**RE: Comment on EIS – Residential Flat Building development at 242-244 Beecroft Rd, Epping (SSD 8784)**

The City of Parramatta Council thanks you for the opportunity to comment on the Environmental Impact Statement for the proposed residential development at 242-244 Beecroft Rd, Epping.

Figure 3-4 Proposed vehicular access and surrounding street hierarchy

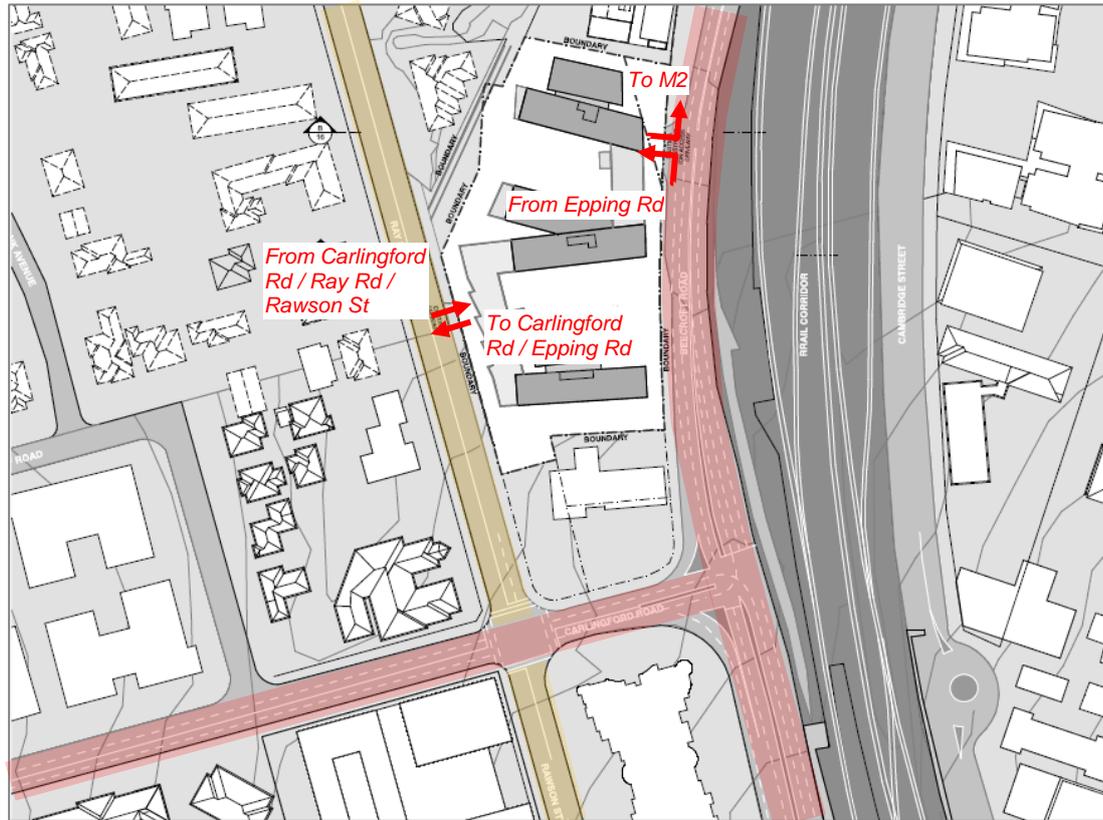
1. Council's traffic study has identified that the provision of a link road through the site connecting Ray and Beecroft Roads will take the pressure off peak hour traffic delays and congestion at key intersections in the long term when coupled with other identified road improvements. Given that funding is being secured for local improvements through the relevant contributions plan and state government funding has been secured for projects such as the widening of the bridge over the railway line, it is essential that this key piece of infrastructure is also secured.

A whole-of-Government approach is required to alleviate the worsening traffic congestion in Epping Town Centre as a result of the rate of growth. Council has initiated a series of actions to assist in delivering local traffic works and also advocating for the NSW Government to undertake certain road improvement works, including the subject site. Therefore the City of Parramatta recommends the subject application be redesigned to include a link road through the site connecting Ray and Beecroft Roads.

**Figure 3–8 Proposed pedestrian site links**

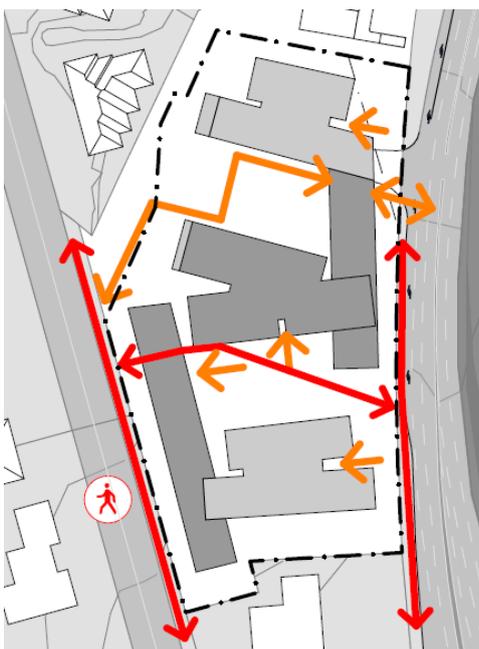
- A 3m wide 24/7 pedestrian connection link between Ray Road and Beecroft Road is required as per the Hornsby DCP.
- Council previously commented on the accessibility of the proposed pedestrian link. The proposed link is not clearly identified and appears to only be accessible by stairs.
- Access to buildings: It is not clear how pedestrians, visitors and delivery people access each building from Ray Road or Beecroft Road.
- The pedestrian link and building lobbies are to have compliant accessible entries and paths of travel with a direct line of sight.
